Former Regal Cinema, 233 High Street, Uxbridge, UB8 1LD

Nimbus Engineering Consultants Ltd

LLFA Comments & Responses

May 2026

TITLE:
Post-Development Impermeable Areas & Exceedance
Routes Plan

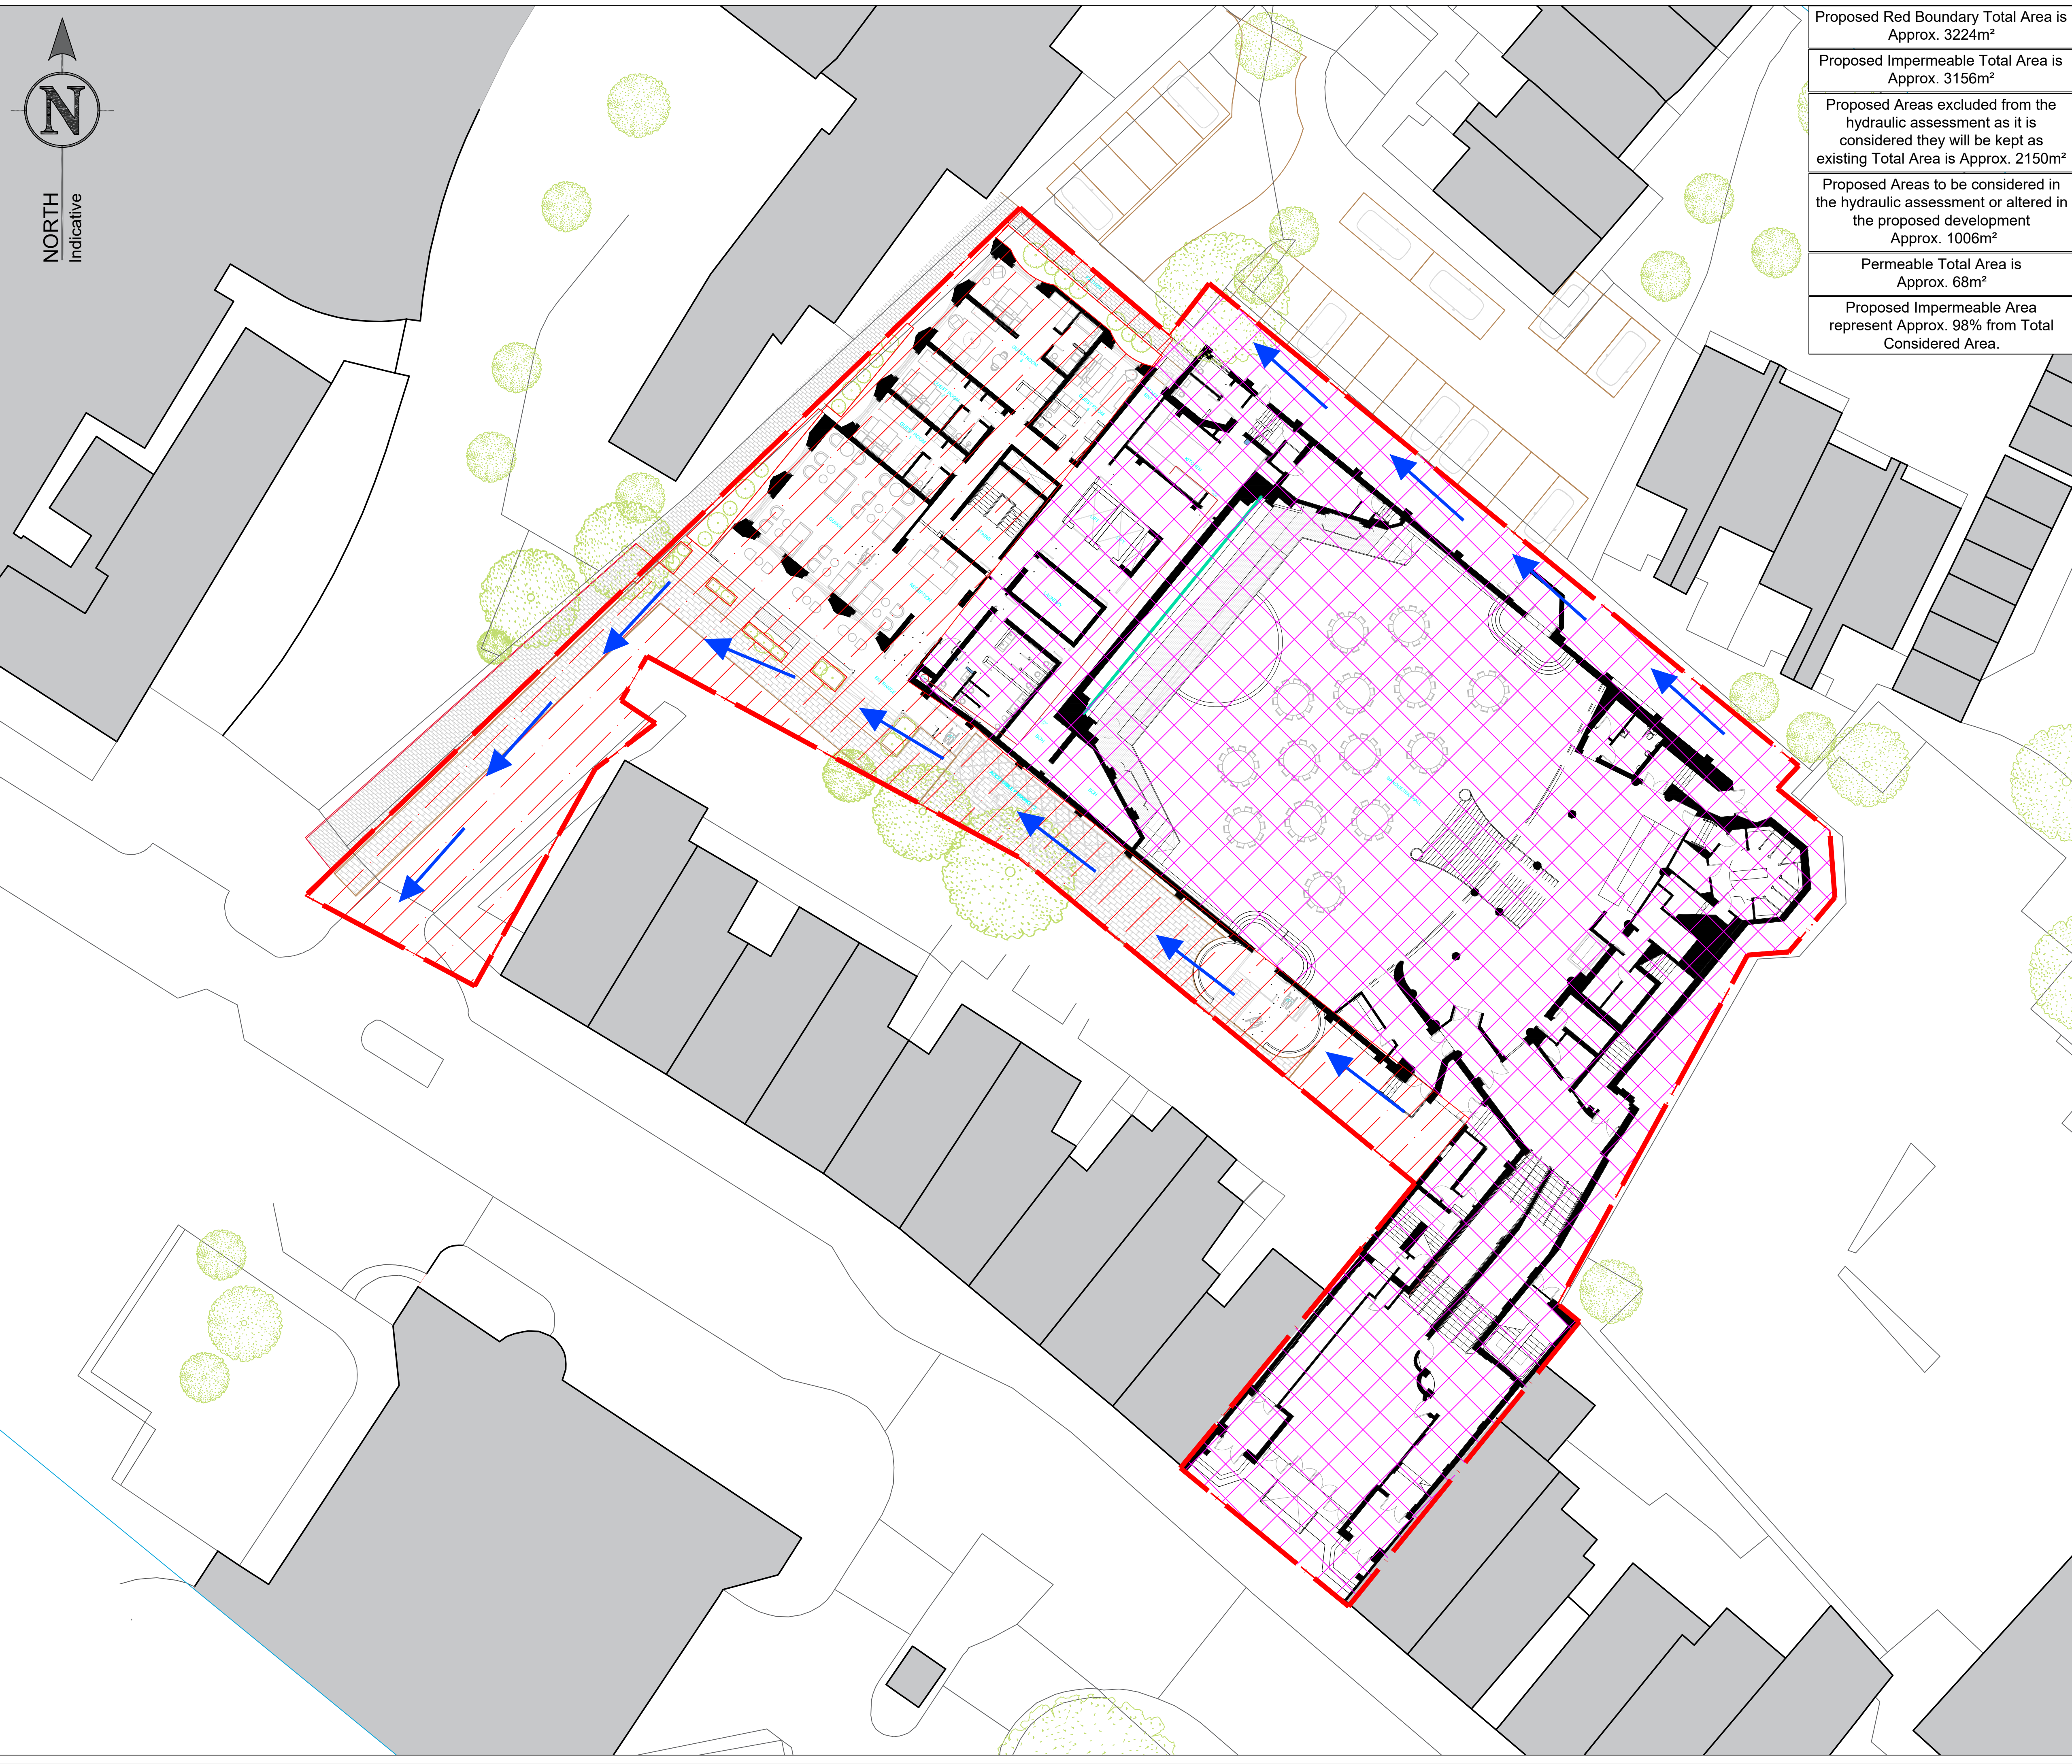
Supplies the greenfield runoff rates for the altered site area of 413m² with the supporting calculations which should demonstrate that the proposed runoff rate does not exceed greenfield runoff rates.

As per the plans provided within Appendix A of the revised FRA & SuDS Report, the altered site area has been increased to 1006m² due to the repaving of the existing access roads and pavings. Revised Qbar calculations have been provided within Appendix B of the FRA & SuDS Report, showing a Qbar(Urban) rate of 1.7 l/s. This has been used in the proposed drainage strategy.

CHECKED BY: S.L	DATE: 07-05-26	APPROVED BY: S.L	DATE: 07-05-26
DRN BY: M.HAM	SCALE: 1:200	DRAWING NUMBER: C3783-03	REV: A
DATE: 07-05-26	SIZE: A1

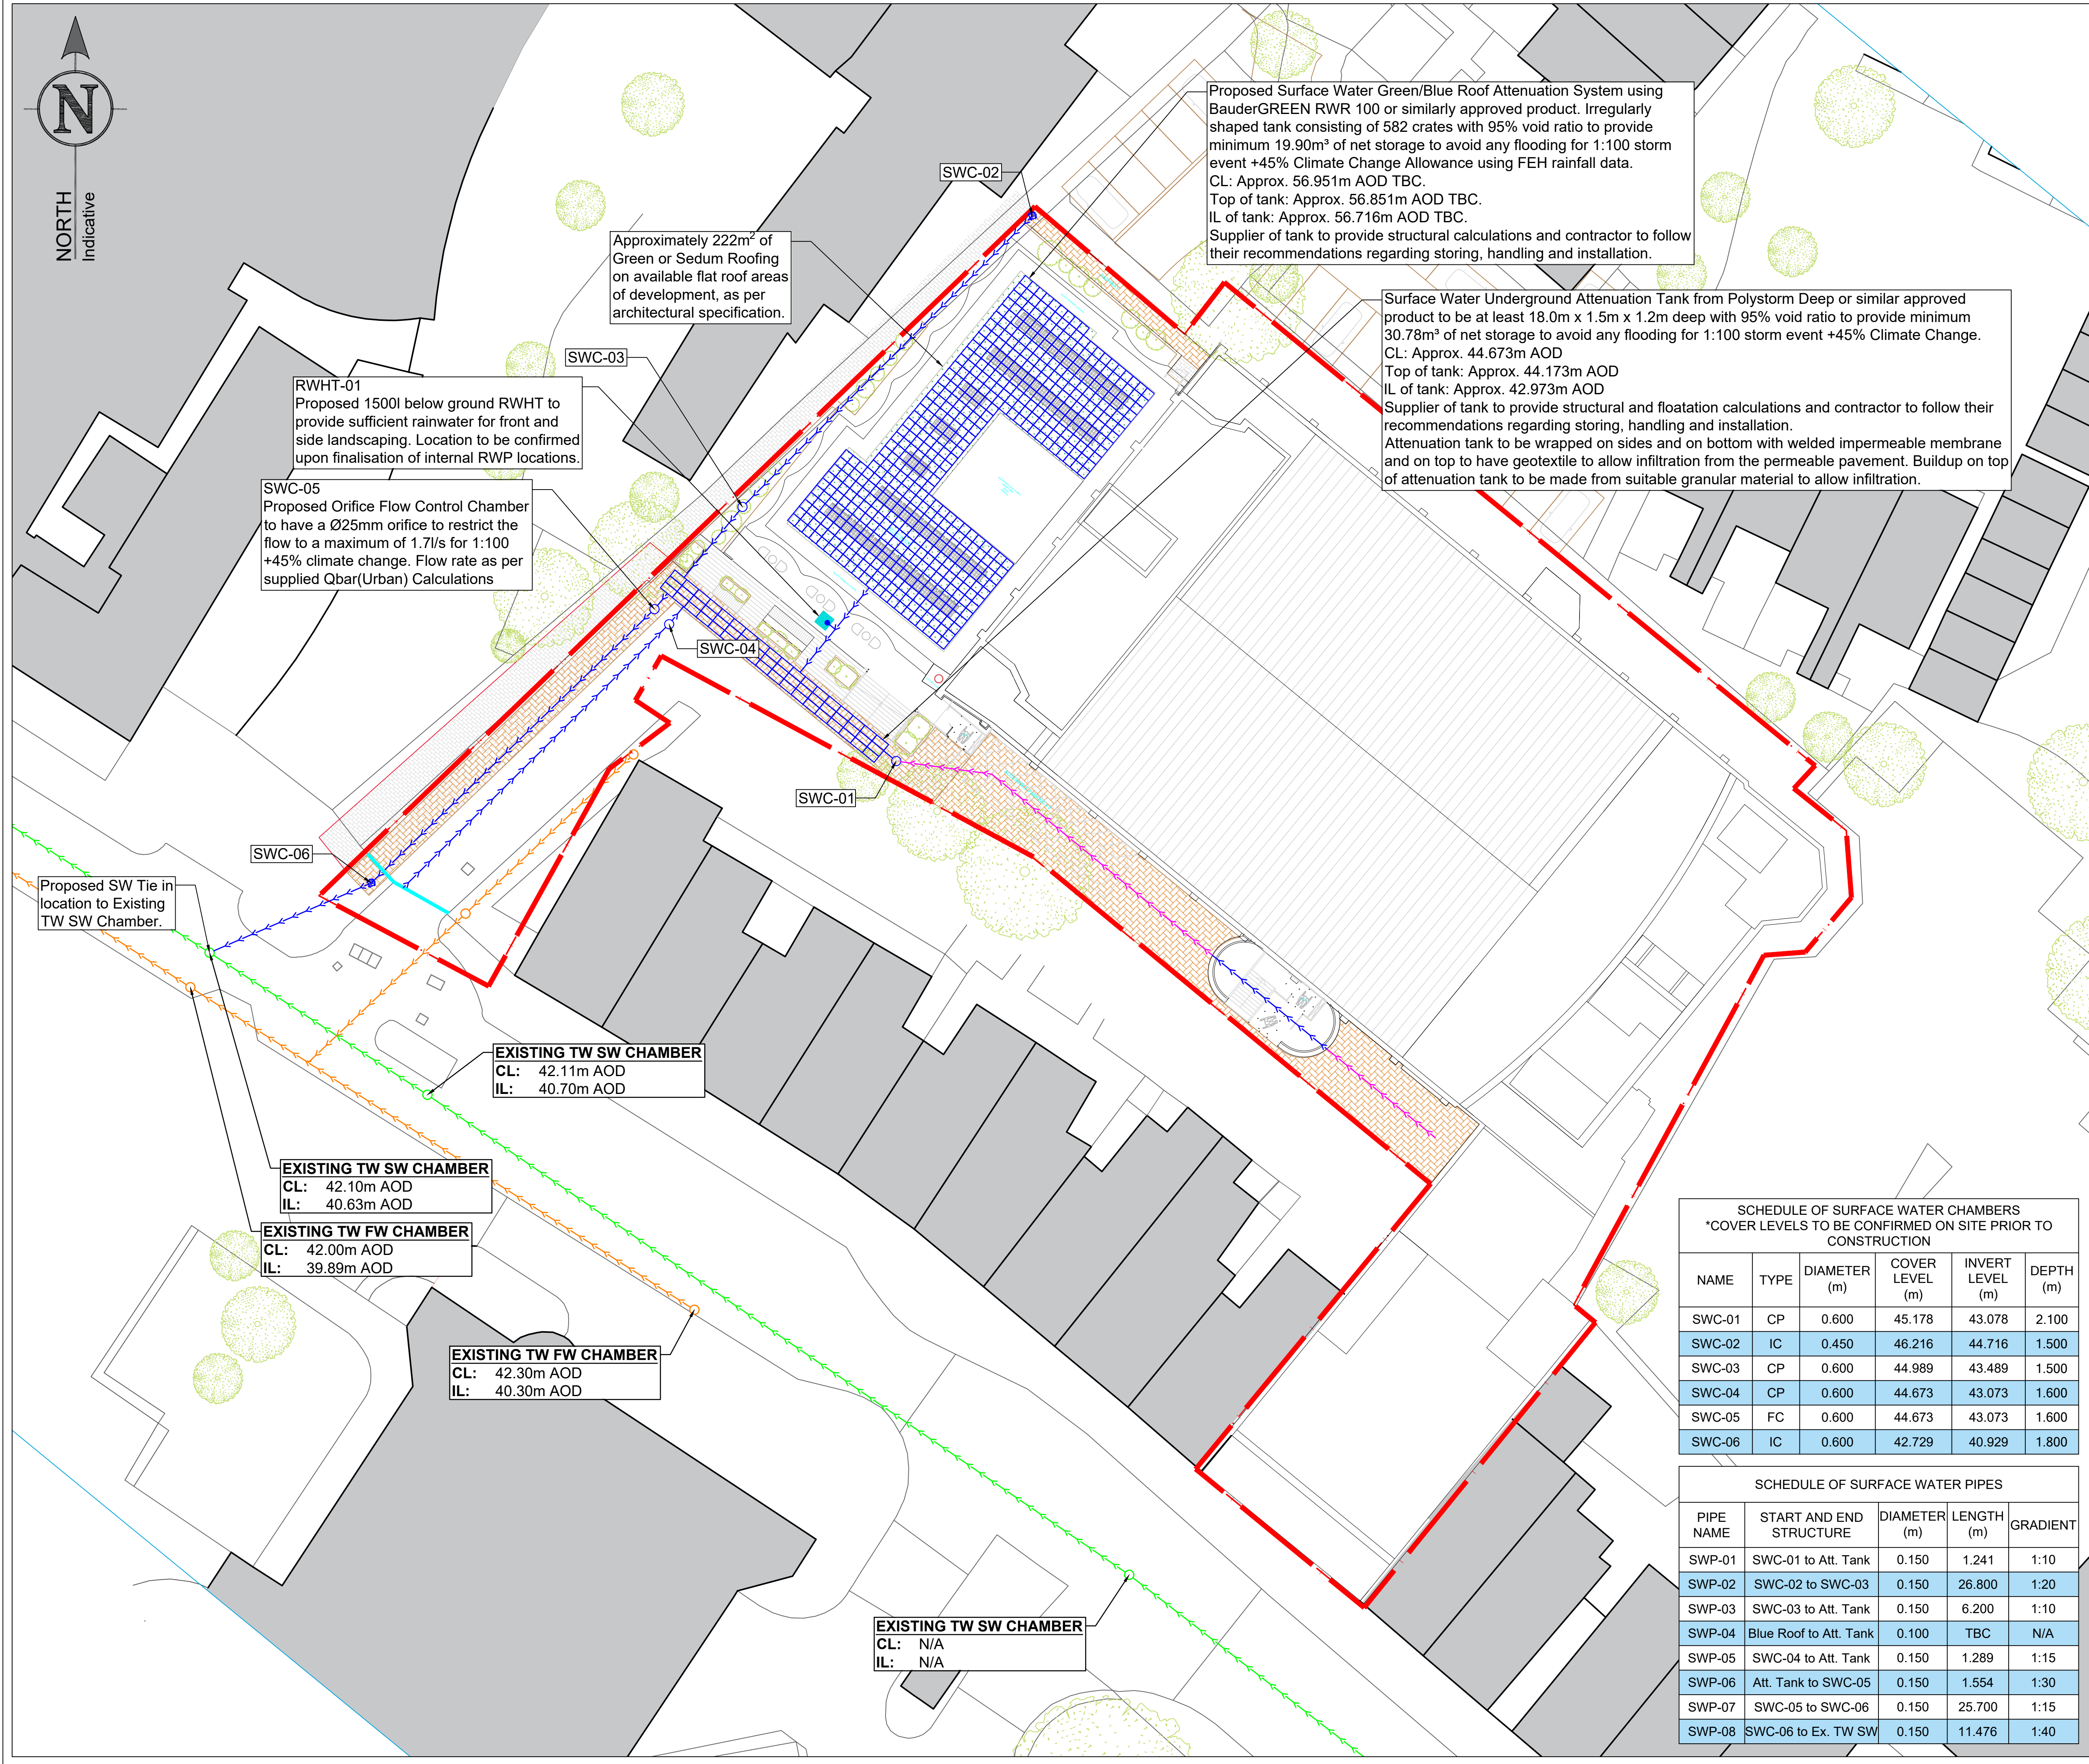
Justifies why green infrastructure has not been incorporated into the drainage strategy which is required as part of the London Plan drainage hierarchy.

Includes the rainwater harvesting tanks with their connections of the Detailed SuDS & Surface Water Layout Plan.

222m² of sedum or green roofing has been proposed on the flat roof areas of the proposed hotel. This can be seen in the revised FRA & SuDS Report, and outlined within C3783-03 within Appendix A.

As all rainwater pipes are to be internal, a large below ground harvesting tank has been proposed towards the front entrance. This can be seen in the revised FRA & SuDS Report, and within C3783-03 within Appendix A.
